Your Ref: OWPC25790
Our Ref: FP/23/20/PL 31-01-2020
Please ask for:
James Cross

Variation of conditions imposed under FP/195/18/PL relating to conditons 2 - approved plans (proposed plot plan, proposed first floor plan, proposed elevations, proposed cross section 'AA'), 4 - vehicle access construction & 5 -vehicle parking & turning spaces.

2 Second Avenue Felpham

PROPOSED FIRST FLOOR PLAN

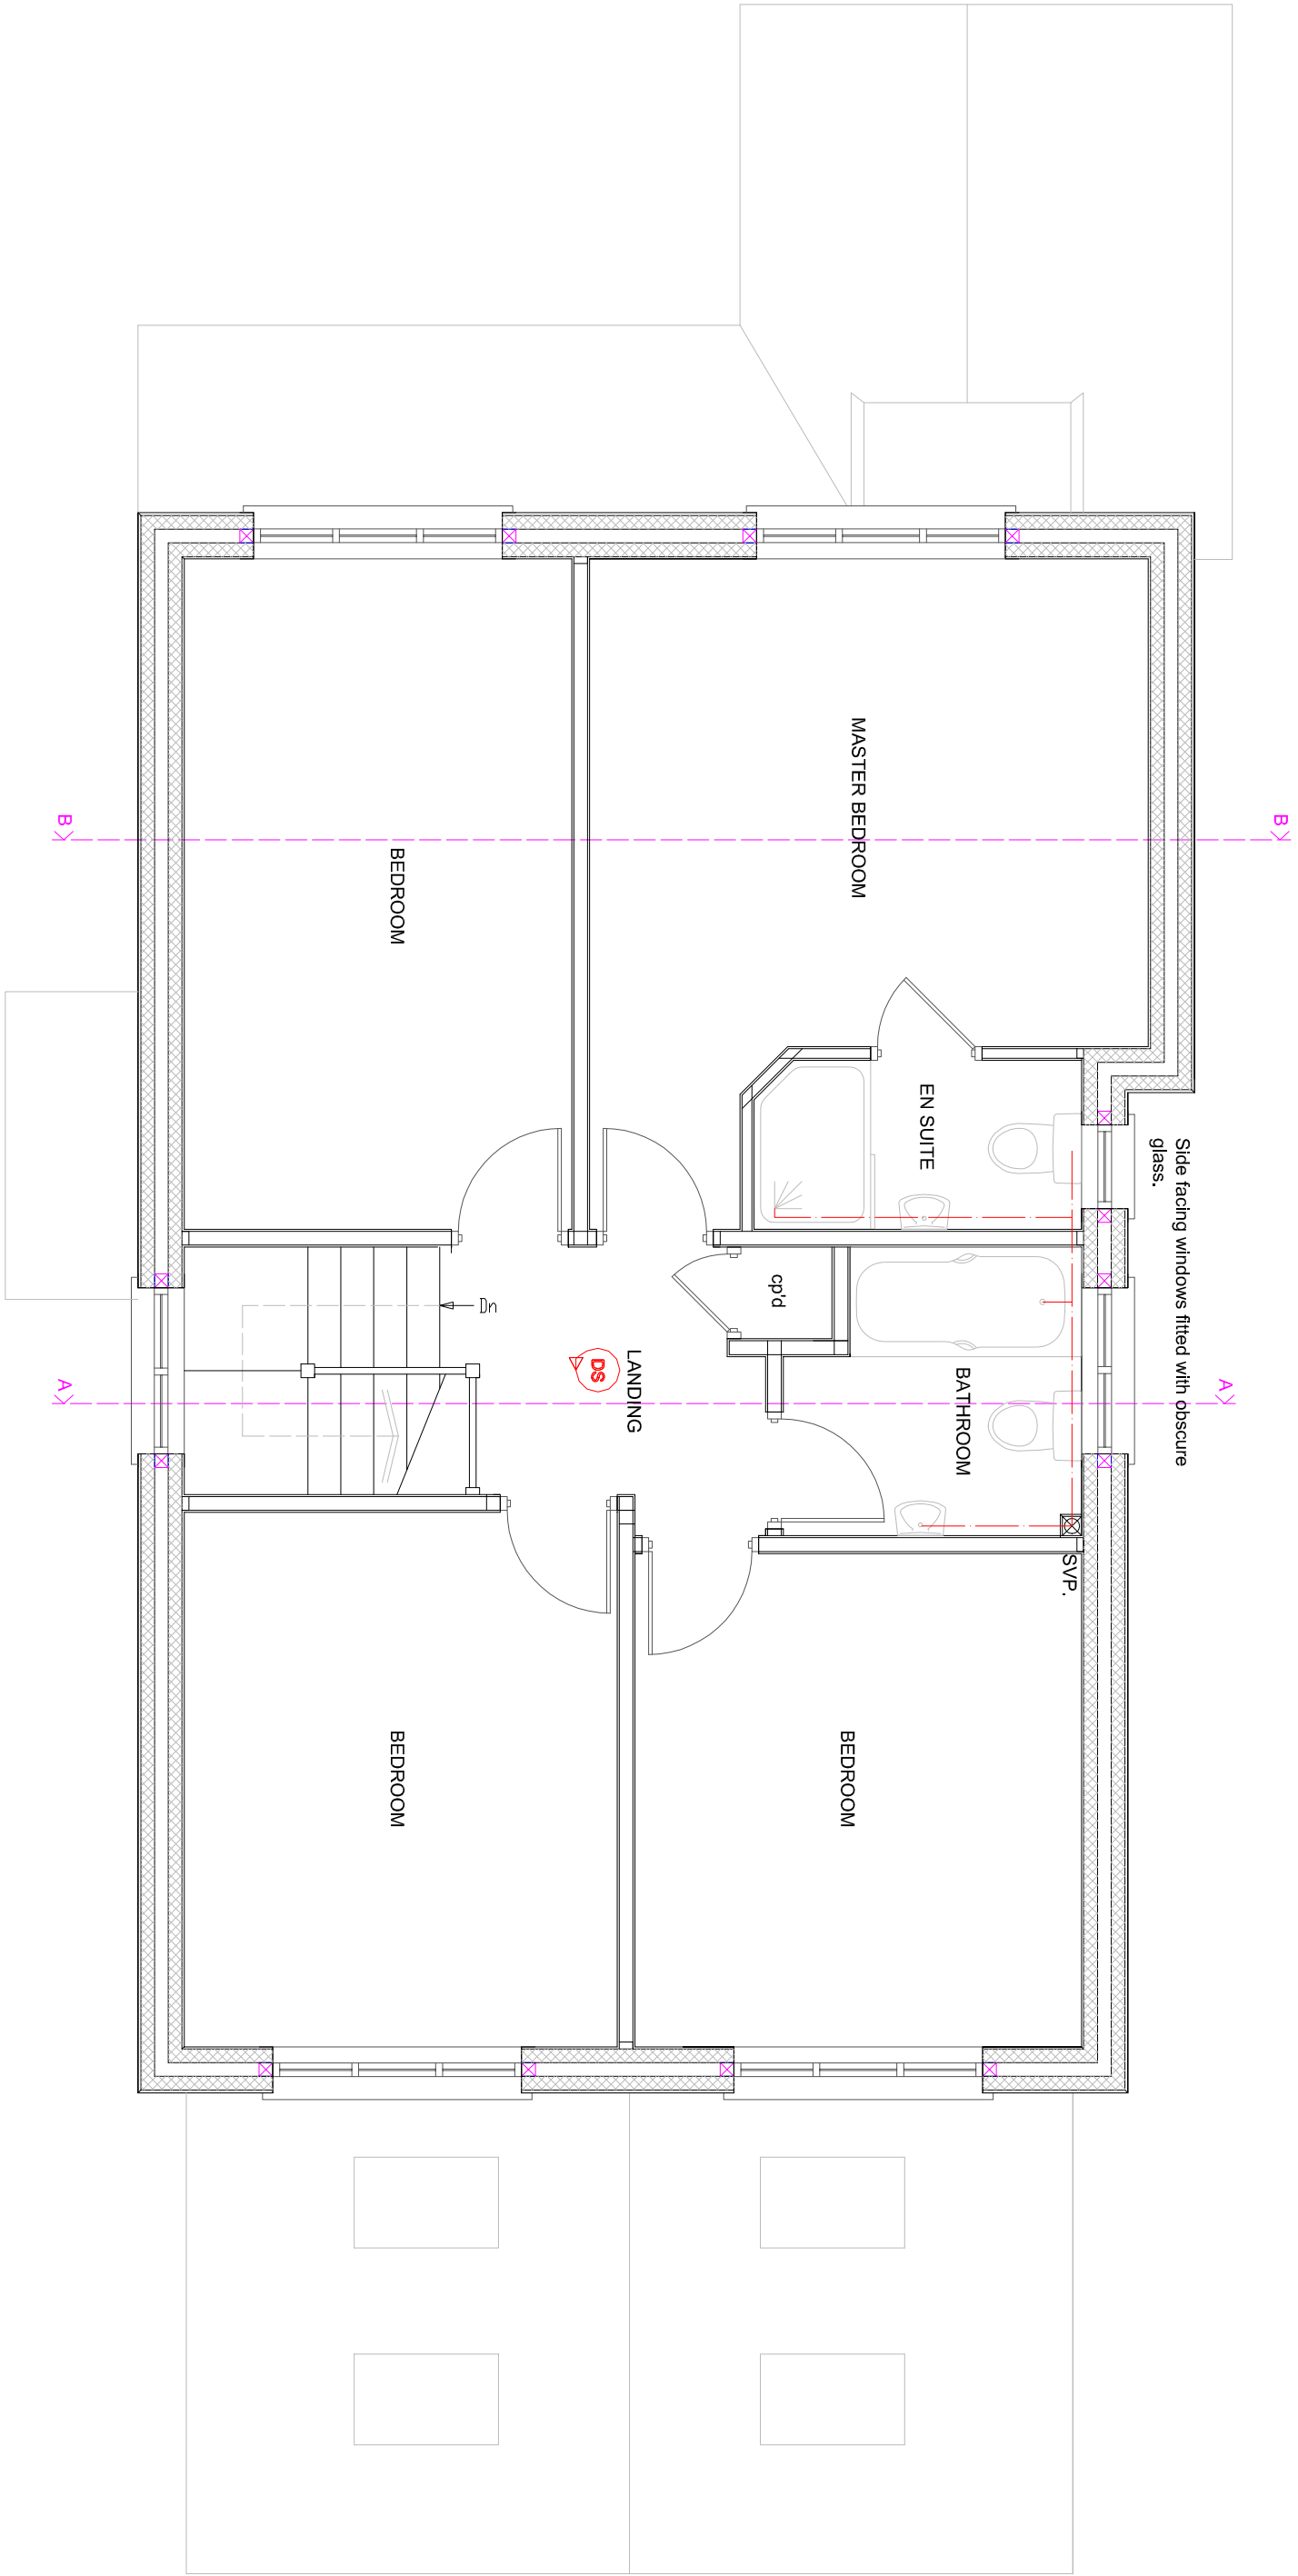
The roof line appears far too high compared to nearby houses. Where it appears the windows will go,they will look directly into my garden, impacting on my privacy,will they have clear glass or obscure?
